KITTITAS COUNTY DEPARTMENT OF PUBLIC WORKS

MEMORANDUM

TO: Community Development Services
FROM: Taylor Gustafson, Environmental/Transportation Planner
DATE: January 3, 2019
SUBJECT: Public Works Review of Short Plat SP-18-00008 (Harmon) TG

HARMON SHORT PLAT

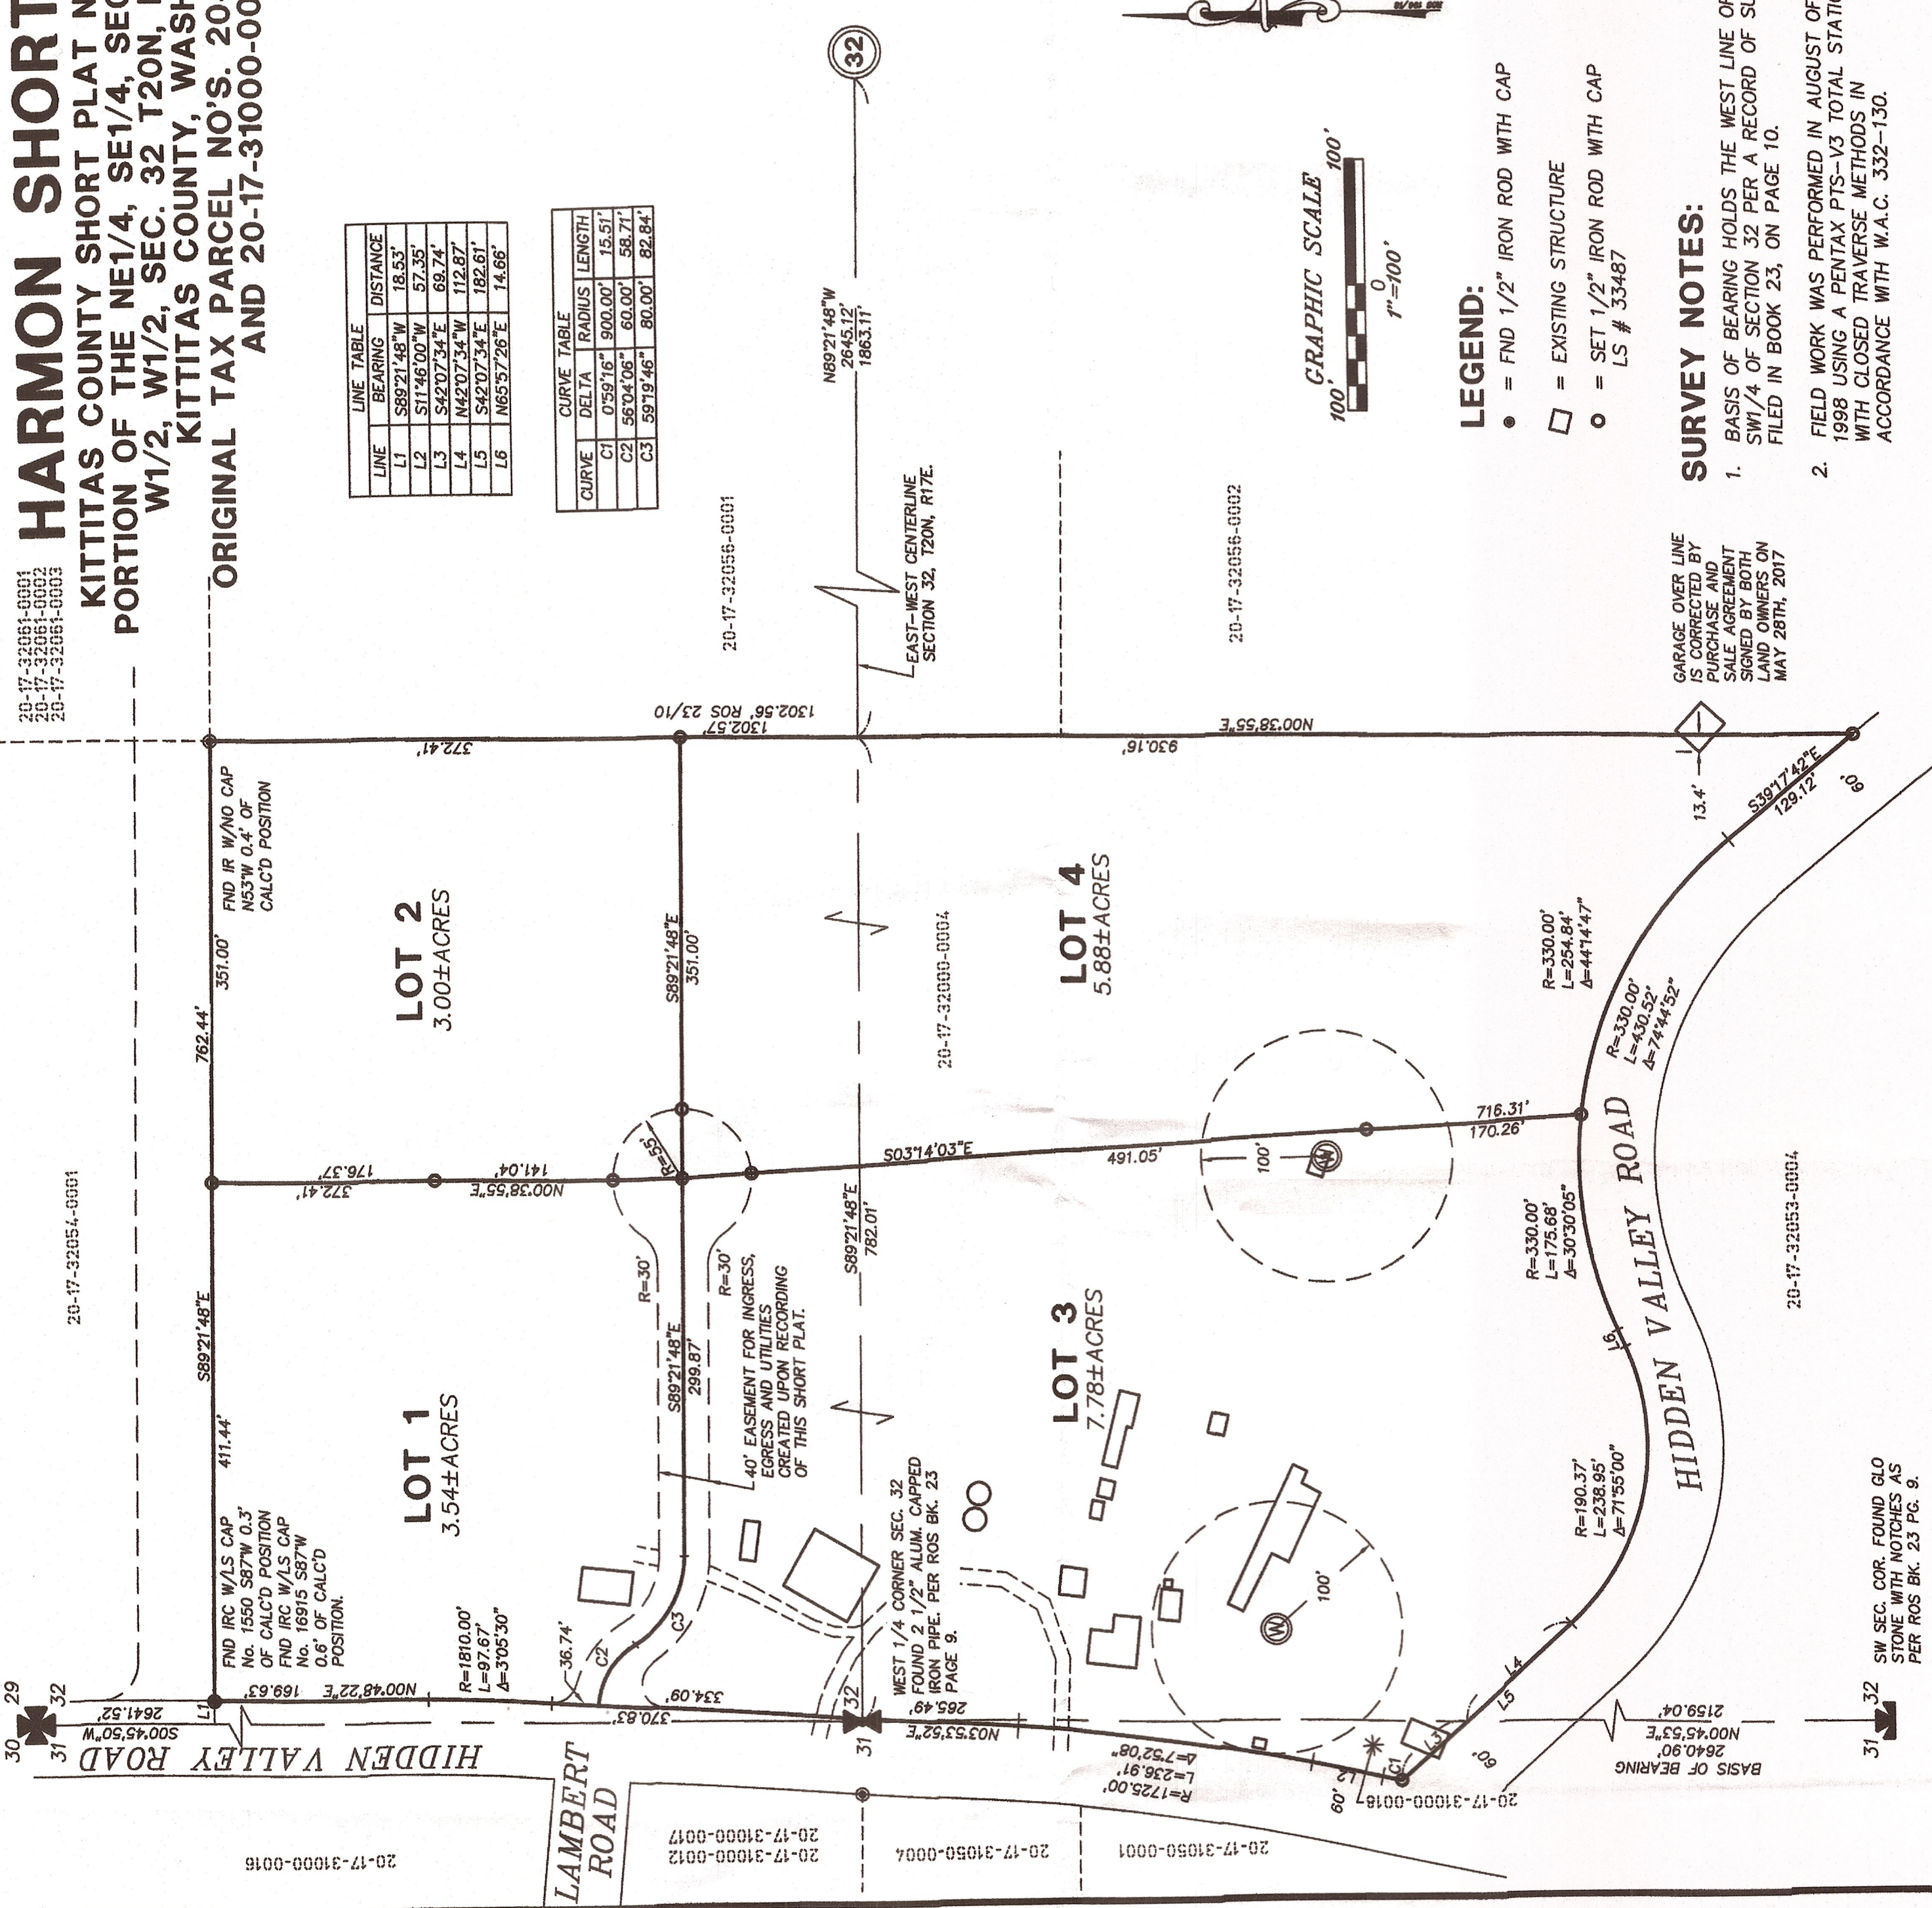
1. Some of the section corners shown do not have any details as to whether they were found, set, or calculated positions. Please note that one of the following requirements must be met for all GLO corners:

- a. Reference to recorded document identifying the position (ROS or LCR)
 - b. distance ties to 3 nearby reference points
 - c. distance ties to 2 adjacent GLO corners

2. All roadways must show name, width, underlying ownership, (Private/County/State), easement or R/W and surfacing material.
(EX: Hidden Valley Rd – 60' County R/W – Paved)

3. The relationship between the property lines and the section lines are confusing, particularly in the area near the West $\frac{1}{4}$ corner of Section 32. The use of "crow'sfeet" to reference what line segment the distances refer to would be useful. It is uncertain what the distance shown as "265.49" is referring to, and whether the section corner actually falls on the property line.

4. The due to the geometry of the curve labeled as "C1" it is difficult to deduce whether it is a curve to the left or the right. A note, a chord bearing, or showing a portion of the radial lines (or any other suitable method) would clarify.

5. The radius of the curves on the proposed 40' easement at Hidden Valley Road are missing.
6. The buildings should be labeled. (Shop/Barn/House/etcetera)

7. The 100' circle around the Wells should be labeled as "100' Well Protection Zone".
8. If the intent of the wells is to serve multiple parcels, please include access and utility easements to provide owners with access and supply water to the respective parcels.

9. Identify the amount of trespass onto the Hidden Valley Road R/W, near the SW corner of Lot 3.
10. Change the language of the garage trespass near the SE corner of Lot 4 to "Garage over line is *accepted*...."

11. Acreage shown to 2 decimal places is considered an acceptable level of accuracy. The +/- symbol shown with the acreage is typically utilized for irregular natural boundaries or very large tracts of land. Please include a note if there is a reason the acreage cannot be accurately determined.
